PRELIMINARY/FINAL DRAINAGE REPORT FOR JUDGE ORR RANCHETTES

October, 2017

PCD FILE NO's: SP-17-011
SF-17-021

# JUDGE ORR RANCHETTES PROPOSED DRAINAGE MAP

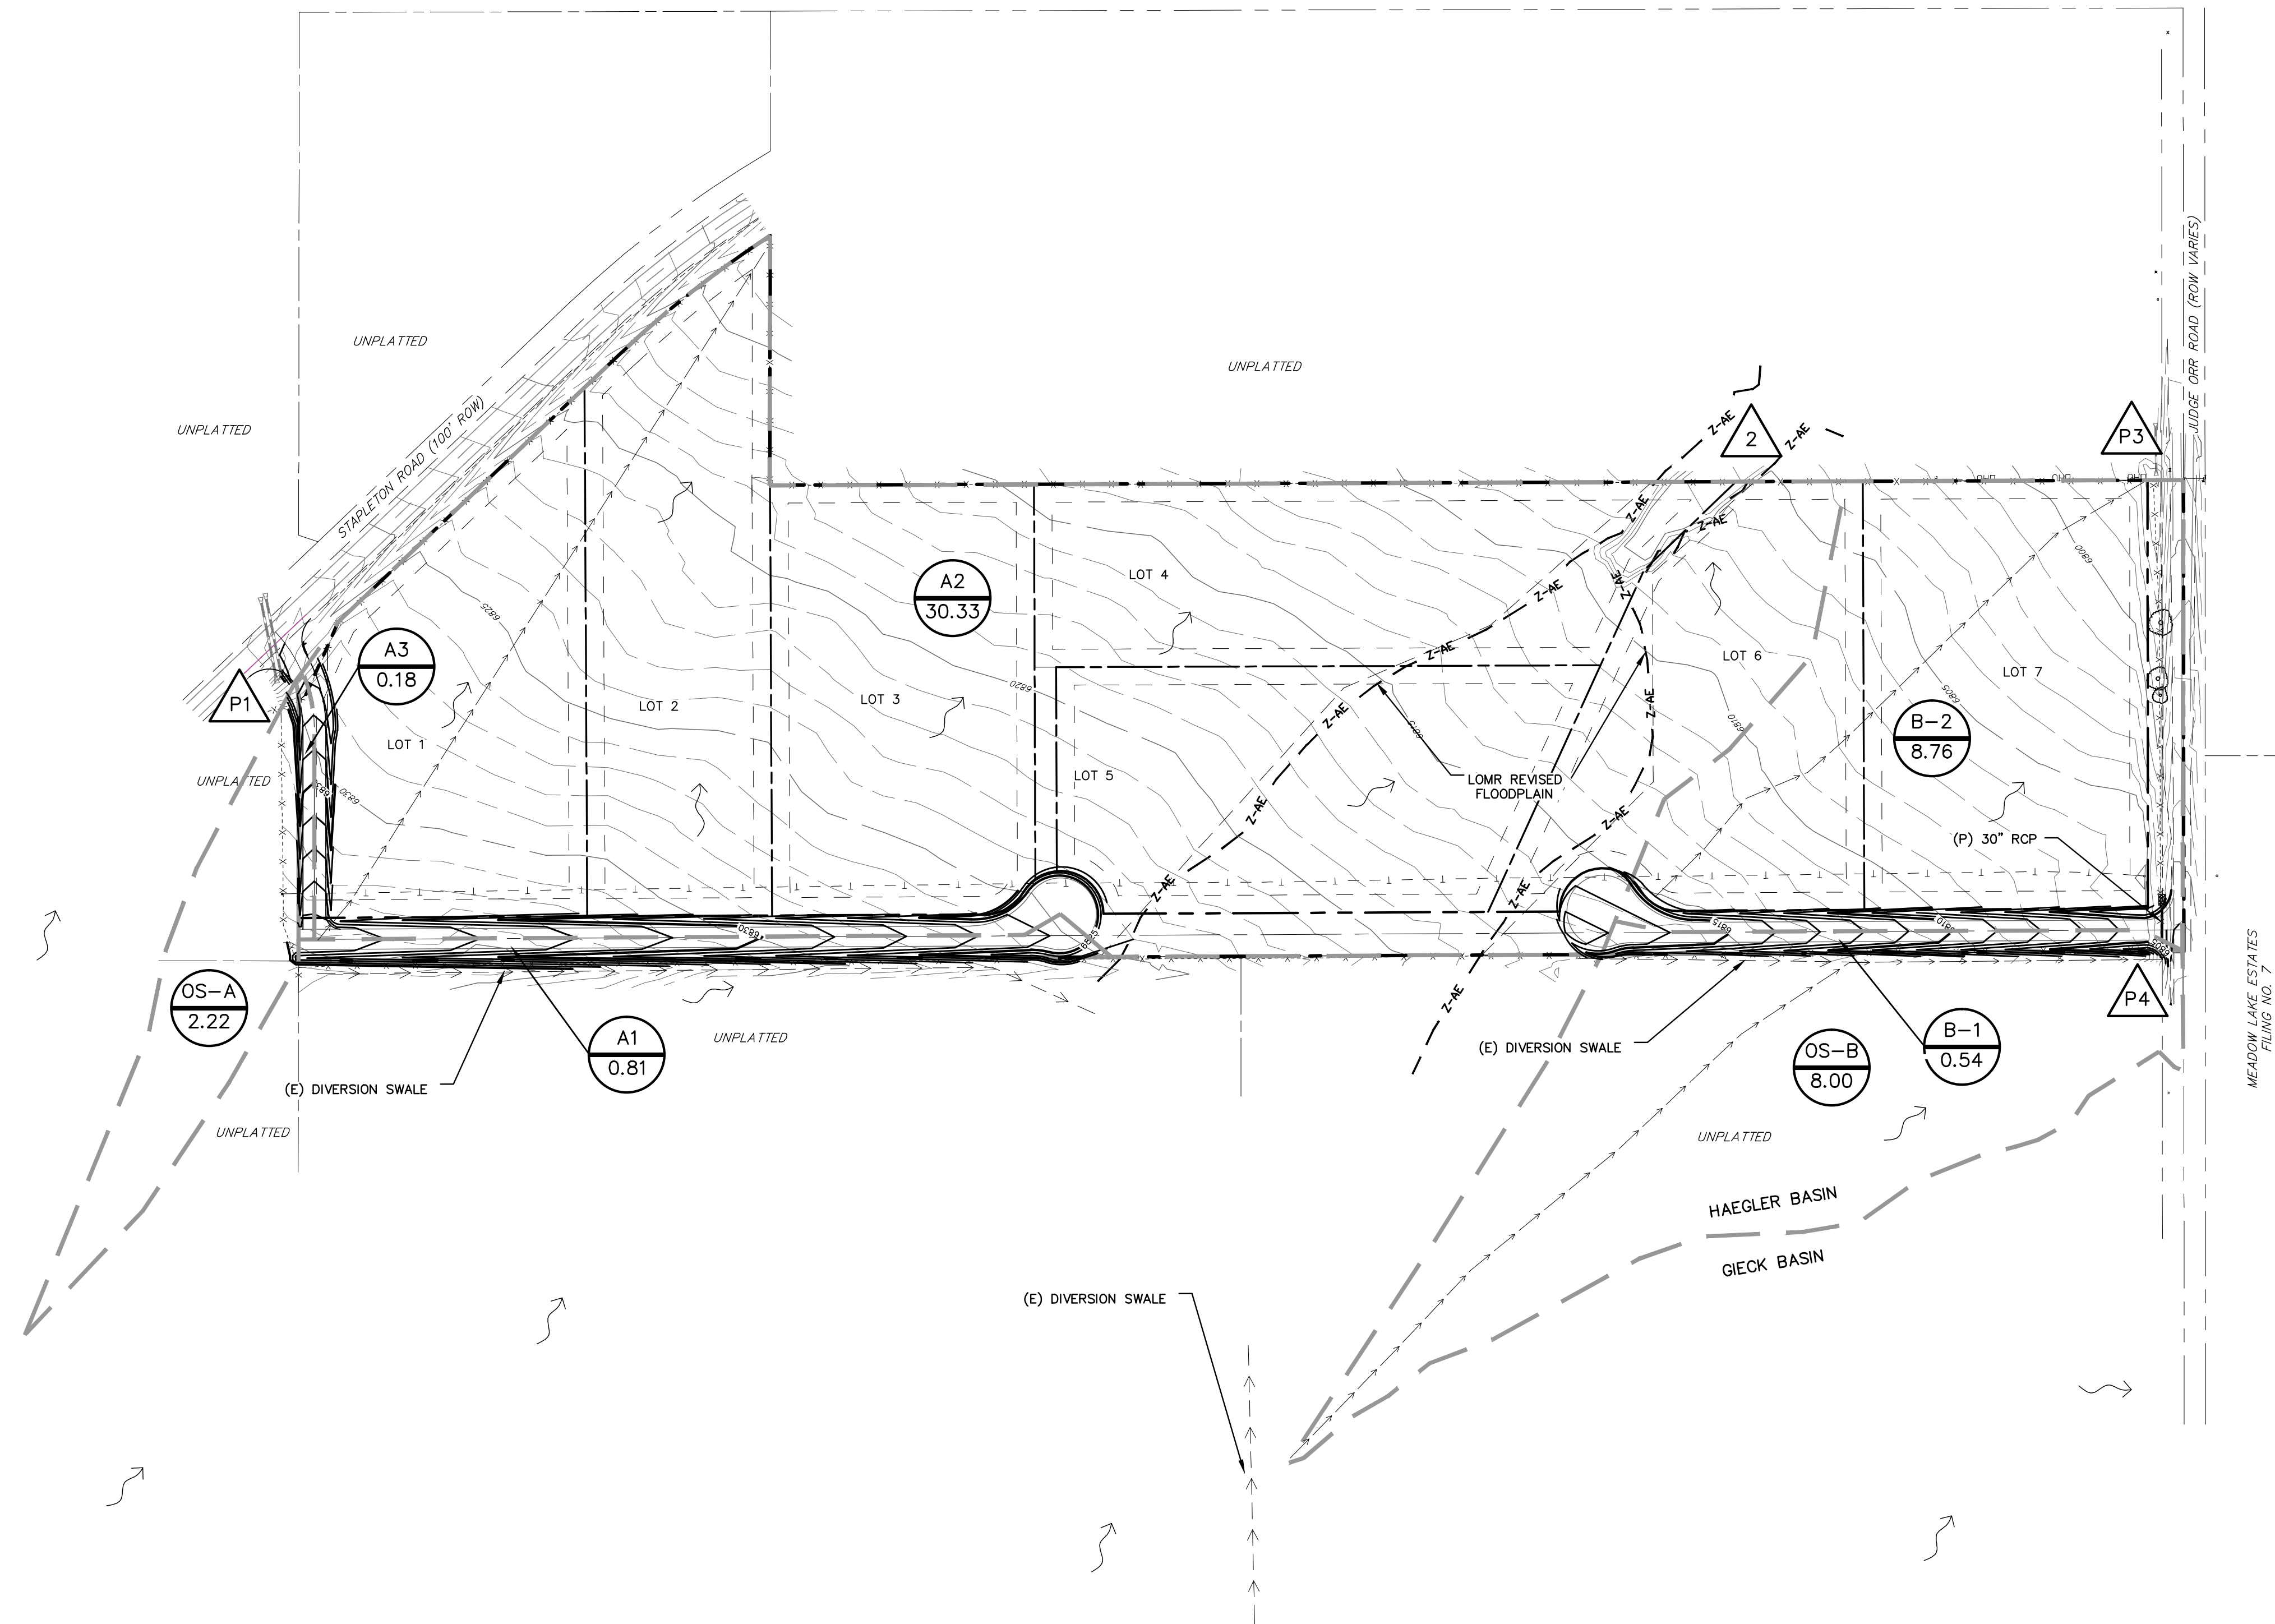
The drainage map shows an existing culvert at DP 3. Provide the calculation and analysis.

Further discussion added.
